30 January 2012

Subject: Teralba Quarry Project (10_0183)

**Lake Macquarie City Council comments on Environmental Assessment
Rhondda Road, Teralba**

Figure 6: Transport Routes

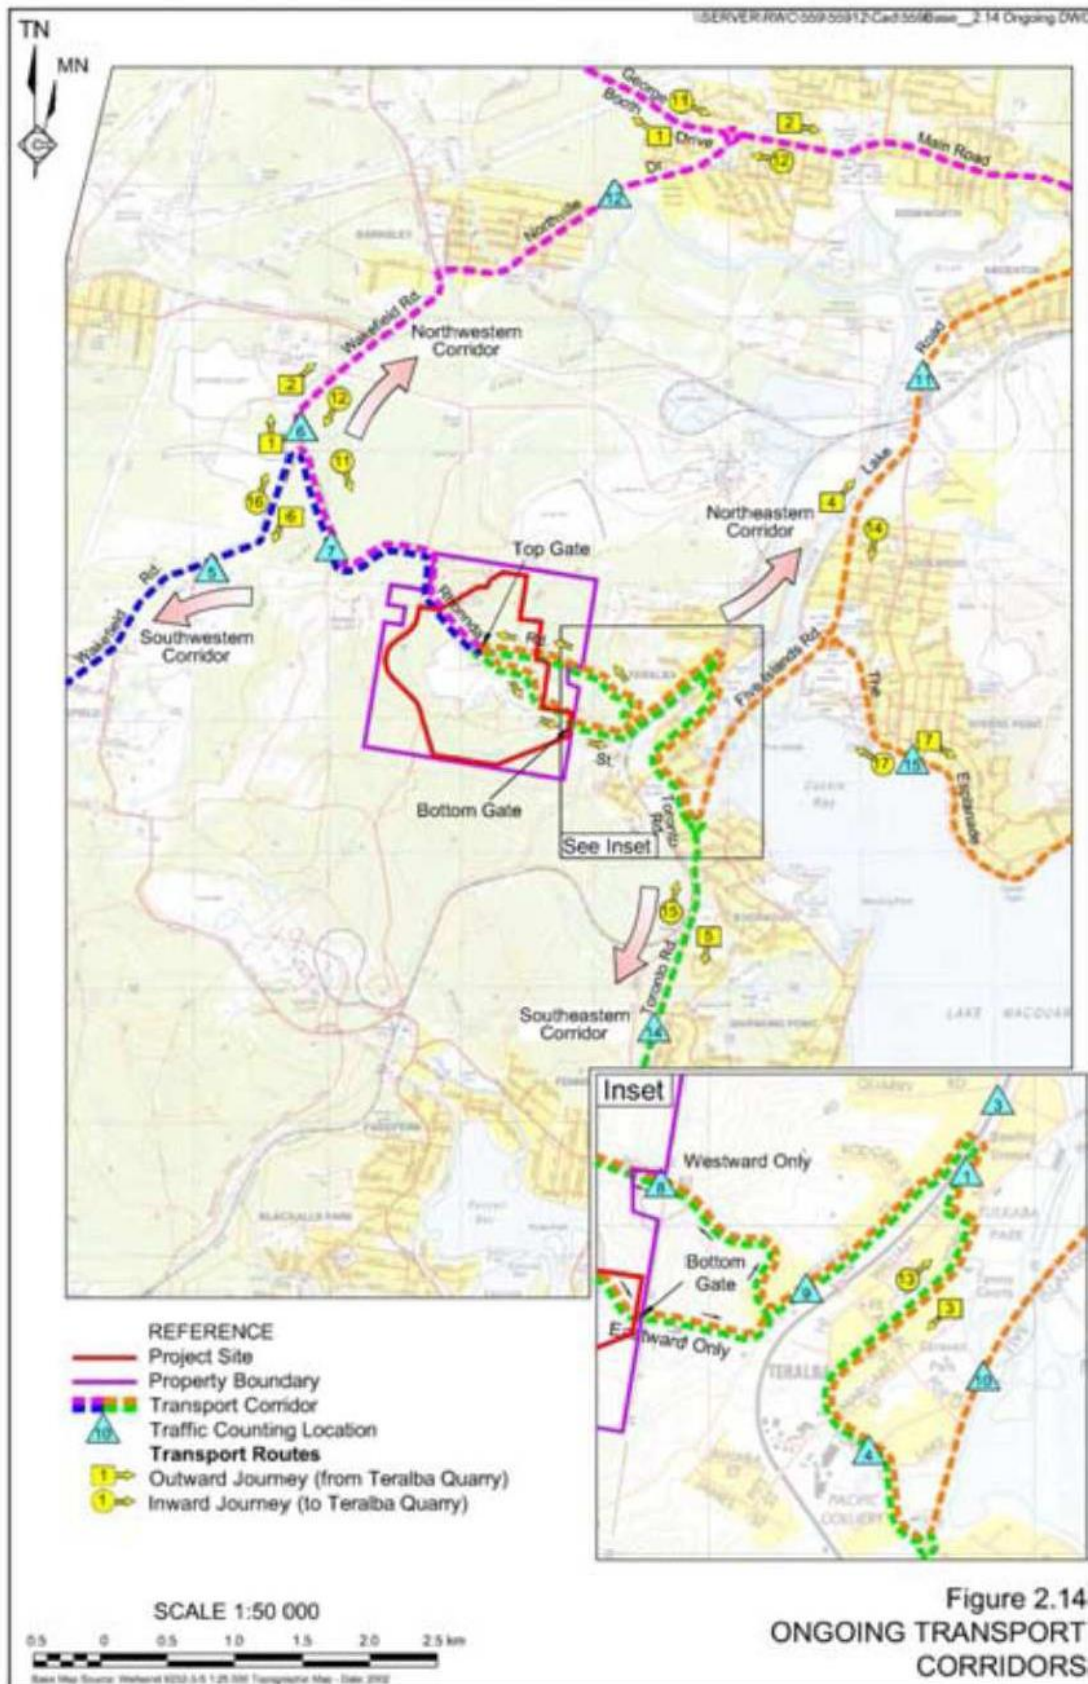
The analysis carried out for the intersection of Pitt and York Streets, Teralba does not take into account the proposed residential subdivision of 600 lots at the end of Pitt Street, which has been approved by Council (DA/3478/2002/B). The analysis should be re-done taking this into account.

Several road sections that are on the proposed routes have major maintenance issues regarding continued need to repair failures caused by heavy vehicles. It is recognised that an open cut mine is nearby and may contribute some traffic into the area, however the bulk of heavy transport appears to be from the Metromix plant.

The loss of economic life for the above roads and the ability to fund the roads replacement at a time that meets the communities' expectation needs to be addressed in this application. The increased traffic usage will deteriorate the roads quickly and maintenance funds will not permit adequate intervention to be sustained. It is expected that with the proposed development sections marked as poor, will require extensive rehabilitation. Roads marked as fair will deteriorate faster with increased truck movements. A full estimate to undertake this work would need a pavement investigation and design.

The above issues could be overcome by Metromix using the coal haulage road on its boundary. The coal haulage road would give the greatest benefit for trip heading south by eliminating the need for heavy vehicles to travel through Teralba, Fennell Bay, and Toronto.

In order for Council to maintain roads effectively for the duration of the plants operation, a maintenance levy per kilometre of road that material is transported on Lake Macquarie City Council maintained road network would be required.

Council requires a contribution for the maintenance of the local road network over the operational life of the proposal. To enable this to occur, Council requires the applicant to enter into a Deed of Agreement with Council to ensure the ongoing maintenance of the local road network prior to consent being issued. This agreement must specify, but not be limited to the following:

Figure 7: Biodiversity Offset

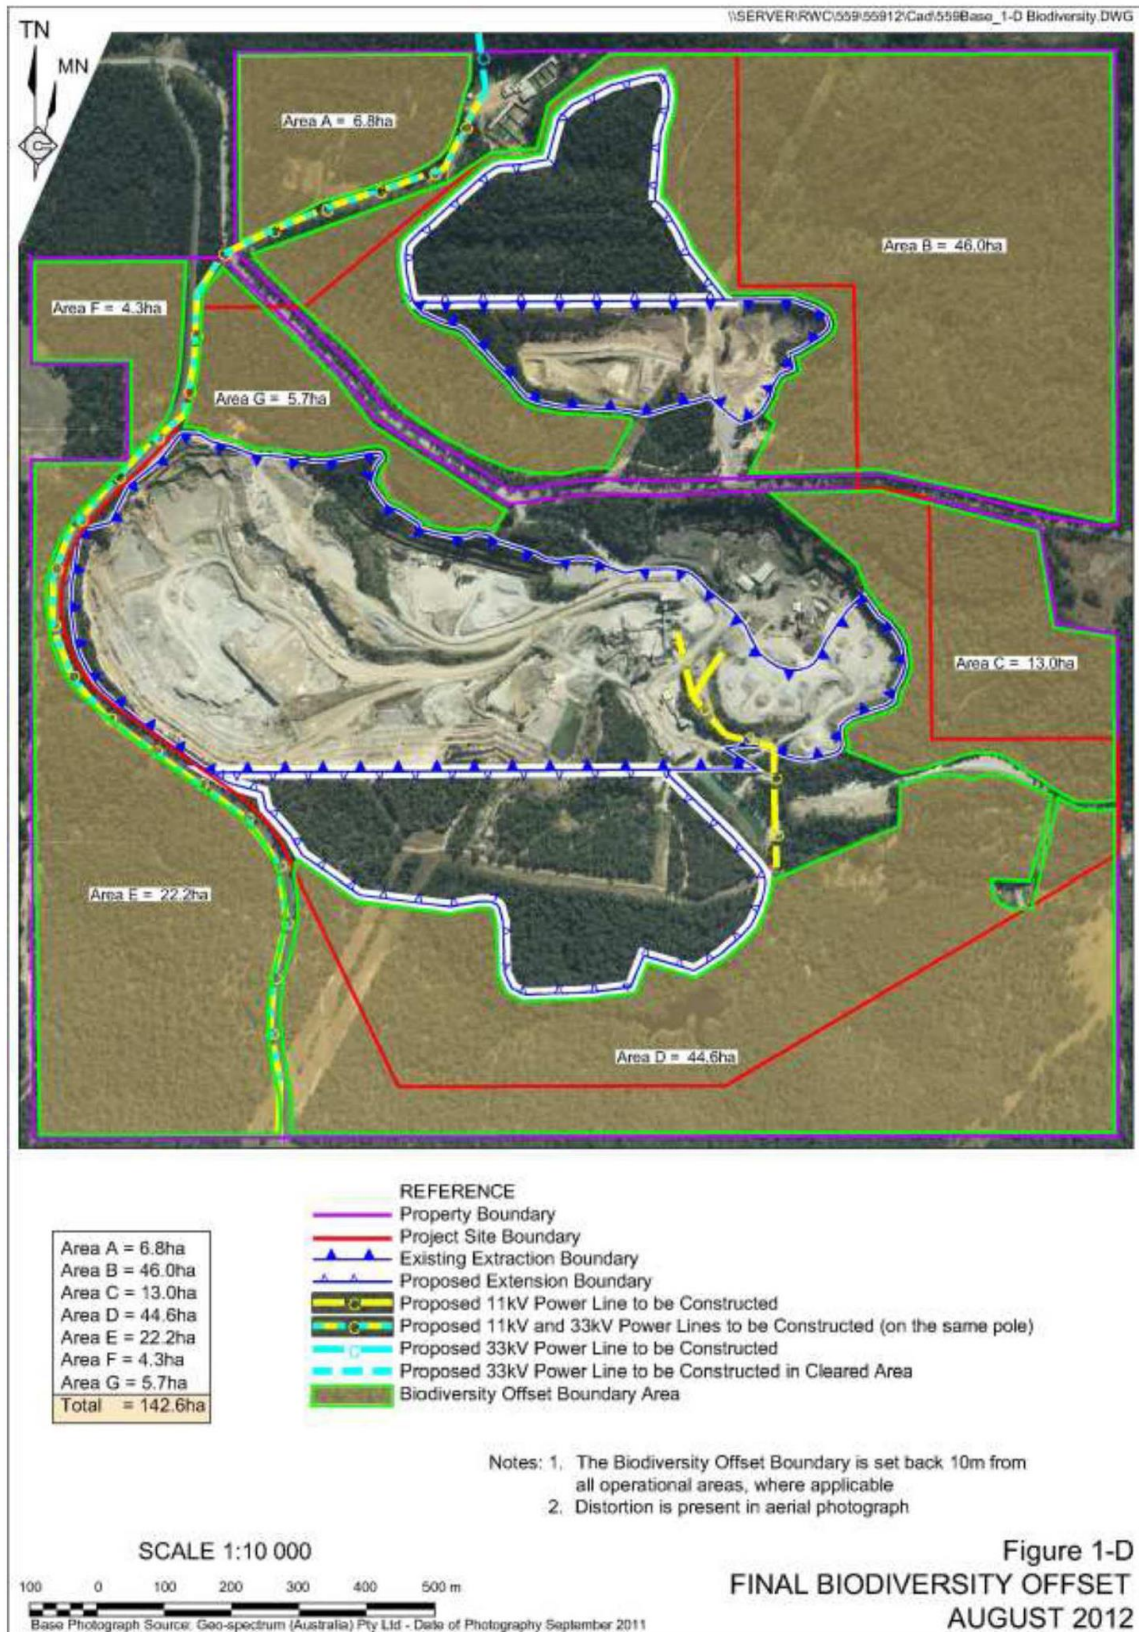
Offset Area – OEH offset principle 7 (App 2 of the Guidelines for Biodiversity Certification of Environmental Planning Instruments – Working Draft DECCW 2007) states that ‘*Offsets must be enduring – they must offset the impact of the development for the period that the impact occurs ... offsets should be agreed prior to the impact occurring*’. It is unclear what mechanism is being used to secure and fund ongoing maintenance of the offset area in perpetuity. Ideally, the offset area would be set aside as national park or equivalent. It is recommended that a VPA or similar mechanism be negotiated and finalised prior to any determination to address this matter.
